Department of Primary Industries

OUT17/25201

Hume Coal Project (SSD 7172) and related Berrima Rail Project (SSD 7171) Comment on the Environmental Impact Statement (EIS)

Hume Coal Project (SSD 7172) and related Berrima Rail Project (SSD 7171) Request for comment on the Environmental Impact Statement DPI Water Detailed Recommendations

Full details of the model design and calibration are provided in Appendix I of the water assessment report (refer to Appendix E).

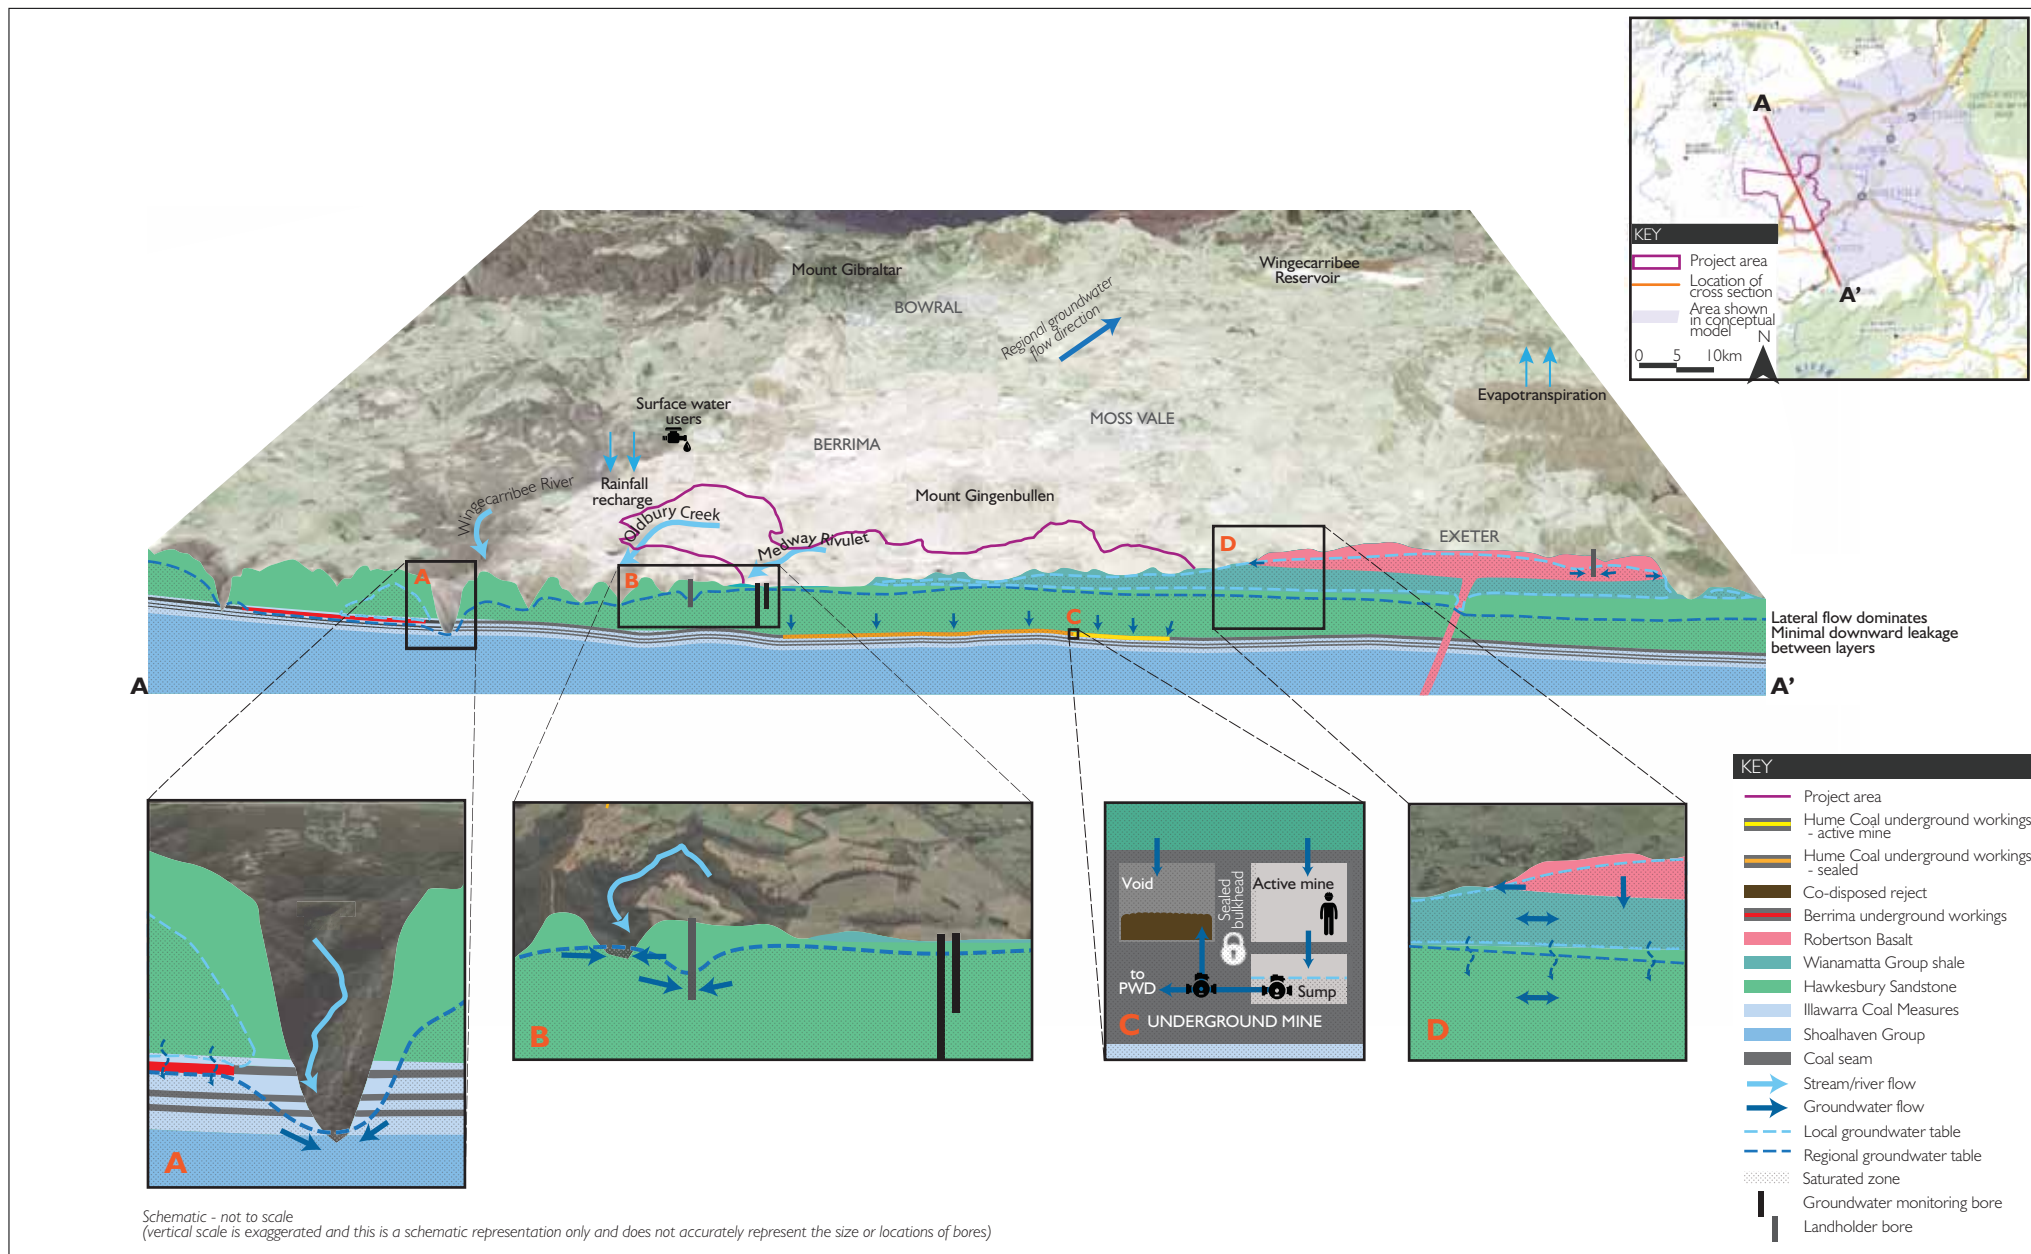
- DPI considers that the groundwater model has a confidence level of class 1, not class 2-3 as stated in the EIS. It should be noted that the Australian Groundwater Modelling Guidelines (pg 19) state that "if a model falls into a Class 1 classification for either the data, calibration or prediction sectors, it should be given a Class 1

model irrespective of all other ratings. The mass balance errors for the calibrated model were within a Class 1 classification. The model should be revisited to achieve the necessary confidence level by reducing water balance errors.

- The groundwater model is considered by DPI Water to have a confidence level of Class 1 rather than the Class 2-3 stated in the environmental assessment (see Attachment C). This is due to the high water balance errors and a higher scaled root mean squared error (SRMS) than recommended by the Australian Groundwater Modelling Guidelines. The model is therefore not considered to be the required class as set by the Australian Groundwater Modelling Guidelines. It should be noted that the Australian Groundwater Modelling Guidelines (pg. 19) state that "if a model falls into a Class 1 classification for either the data, calibration or prediction sectors, it should be given a Class 1 model irrespective of all other ratings. The mass balance errors for the calibrated model were within a Class 1 classification.

- The numerical model, which forms the basis of the predictions and associated mitigation and management measures, needs to be revisited to achieve the necessary confidence level(s) in model predictions in accordance with the Australian Groundwater Modelling Guidelines (see Attachment A and C).

- The model developer needs to attempt to reduce water balance errors, improve the confidence level classification and provide further details of the model calibration (including detailed discussion of the convergence before and after the reworking of the model) (see Attachment A and C).

Figure 7.11 Expected inflow volumes over time

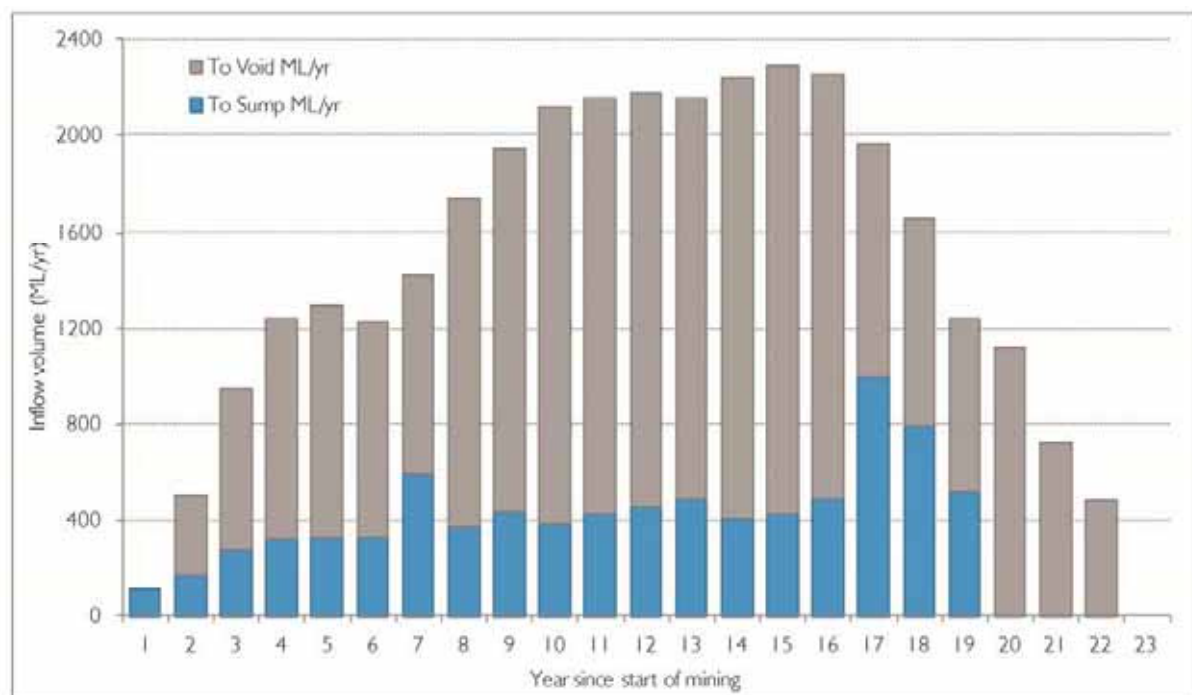
- Based on modelling predictions, the annual inflows to the underground are to range from a minimum of 127 ML in Year 1 to a peak of 2259 ML in Year 15. These inflows induce water take from a number of water sources, which the proponent will be required to obtain entitlements. This includes 844 units in Nepean Management Zone 1, 5.5 units in the Medway Rivulet Zone, 1 unit in Nepean Management Zone 2 and 18 units in the Sydney Basin South. The ability to obtain the entitlement in the Nepean Management Zone 1 is the key concern, as although entitlement is available the ability to acquire this is yet to be confirmed.

- Re-evaluate the volumes required to be licensed based on maximum/worst case conditions (not average conditions) direct and induced take from water sources impacted by the development, and evidence that sufficient entitlement can be obtained.
